Rezoning Transportation Analysis
Petition Number: Insert Zoning Petition #2021-221
General Location Identifier: 04121119

From: Jake Carpenter, PE
Jacob.carpenter@charlottenc.gov
980-221-5675

Revision Log:	Date	Description
	02-24-22	First Review (TM)
	04-20-23	Second Review (ME)
	07-25023	Third Review (TM)

RZ-1.0

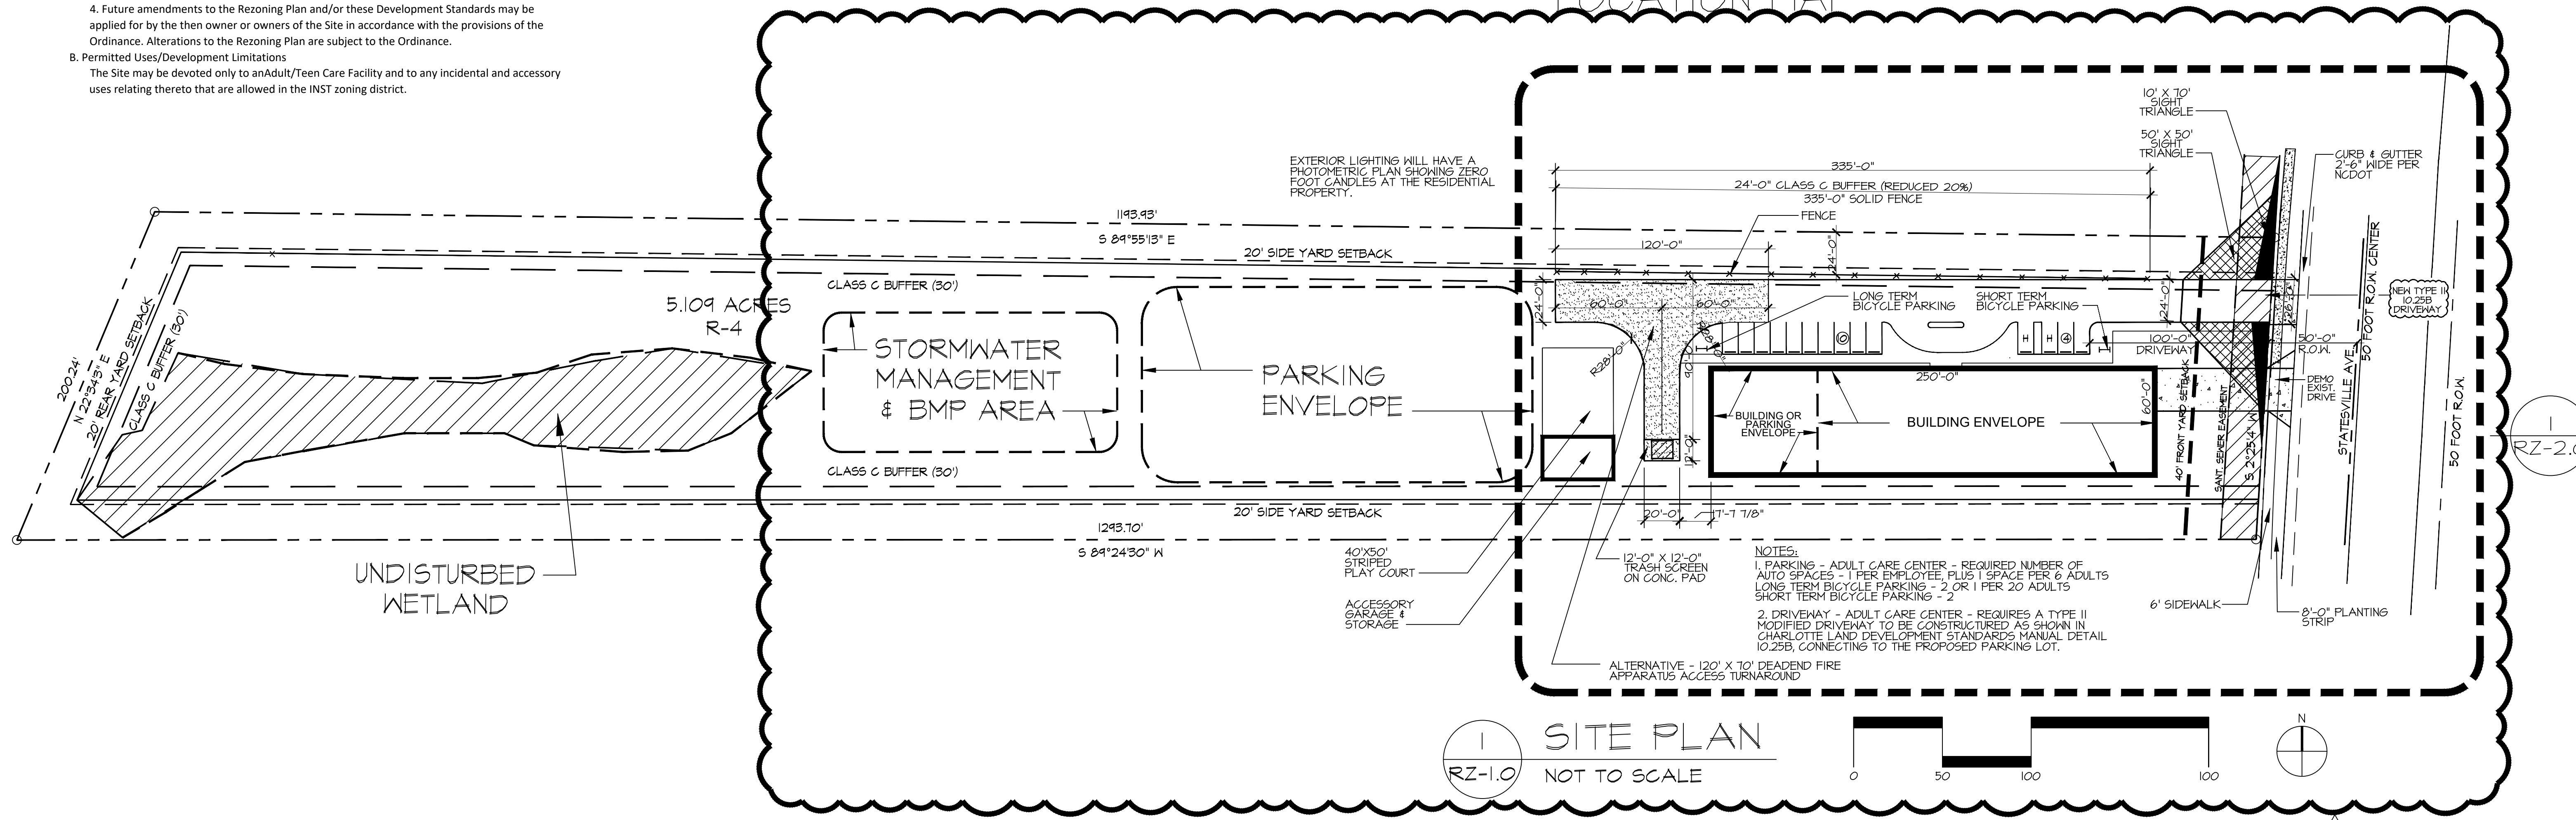
Label and dimension the curb and gutter from the centerline for each road on the site plan.

3. ~~Revise site plan and conditional note(s) to commit to dedicate 50 feet of right-of-way from the road centerline. The site plan shall label and dimension the right-of-way from the road centerline.~~
4. ~~Revise the site plan to dimension the driveway stem length from the right-of-way to the first parking space. A 100-ft minimum length stem length is required per the NCDOT Policy on Street and Driveway Access.~~

- 5. ~~Outstanding Comment From 02-24-22:~~ ~~Revise site plan and conditional note(s) to commit to construct a Type II Modified driveway as depicted in Charlotte Land Development Standards Manual detail 10.25E connecting to the proposed parking lot.~~

- 6. ~~Outstanding Comment From 02-24-22:~~ ~~Revise site plan and conditional note(s) to commit to construct an 8-foot planting strip, and 6-foot sidewalk on Statesville per the council adopted Charlotte WALKS policy. The site plan shall label and dimension both items from the back of curb and gutter and road centerline.~~

- 7. ~~Outstanding Comment From 02-24-22:~~ ~~Revise site plan and conditional note(s) to commit to removal of the existing driveway and replacing the curb and gutter per the Chapter 19 Ordinance requirements. Reference Charlotte Land Development Standards Manual detail 10.17A on plan.~~

RZ-2.0

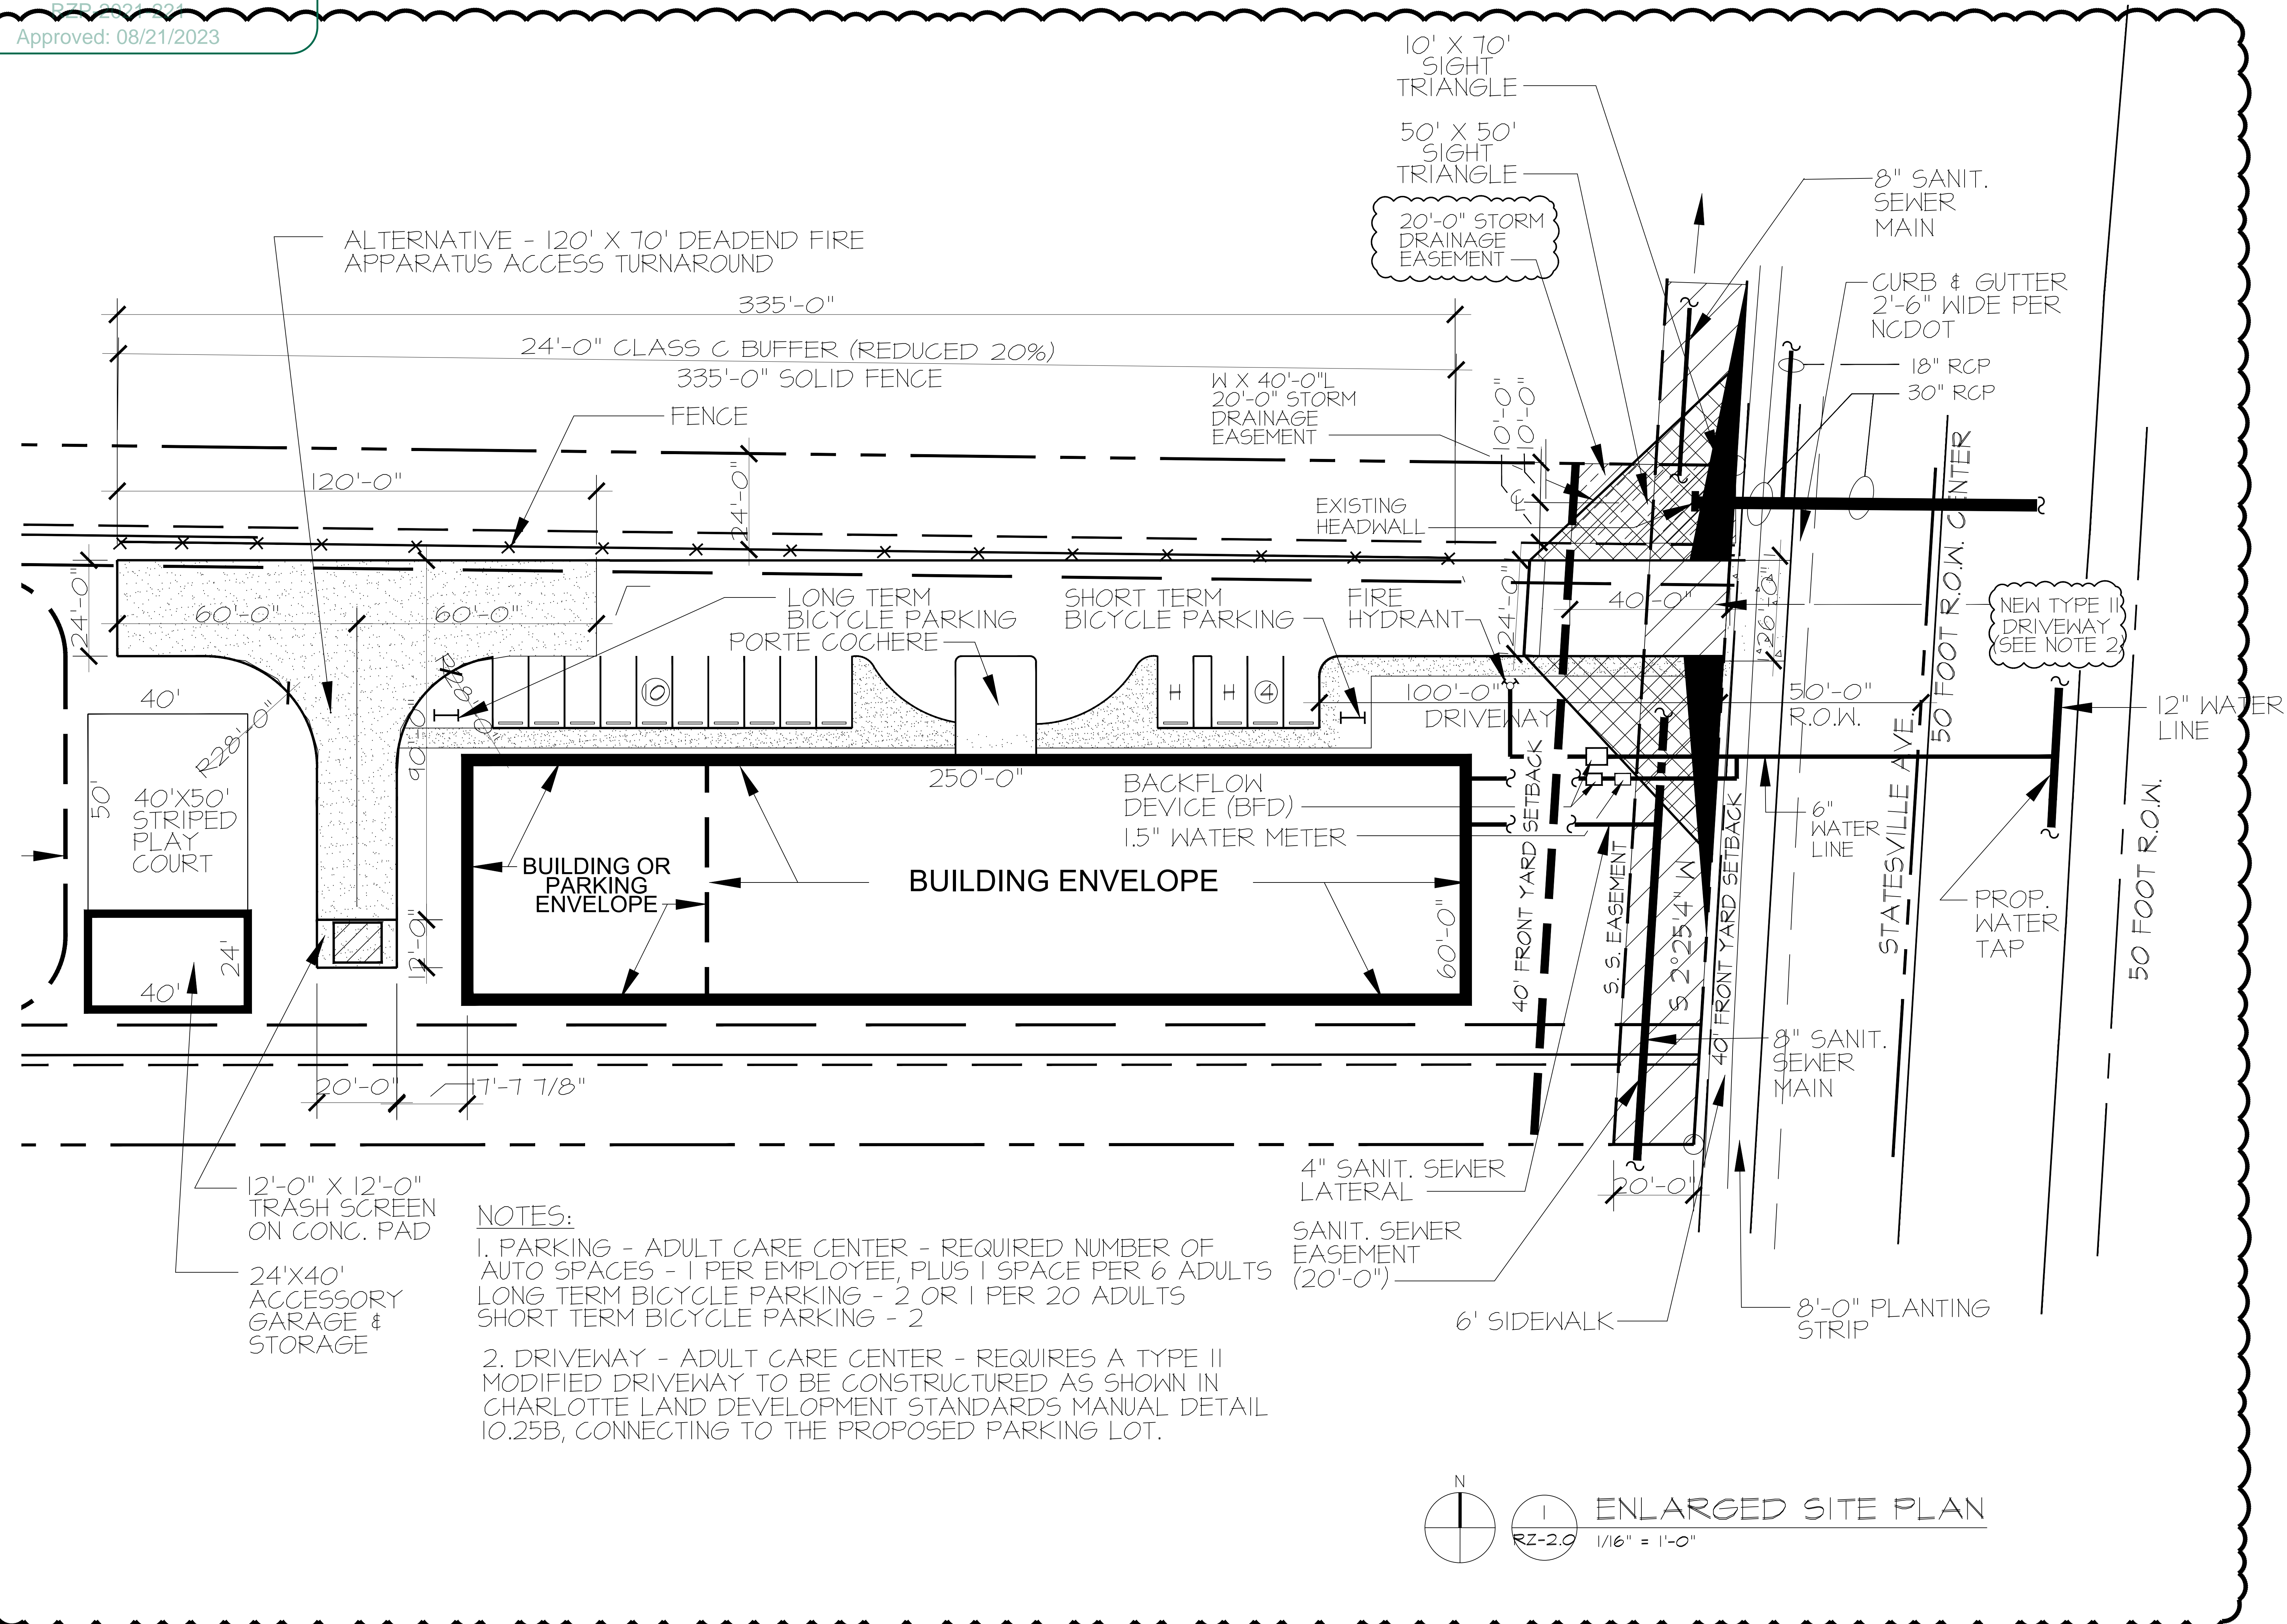
~~Clarifying Comment 04-20-23:~~ ~~There is a label on the site plan referring to the Charlotte Land Development Standards Manual detail 10.25B and it should reference detail 10.25E as stated in conditional notes.~~
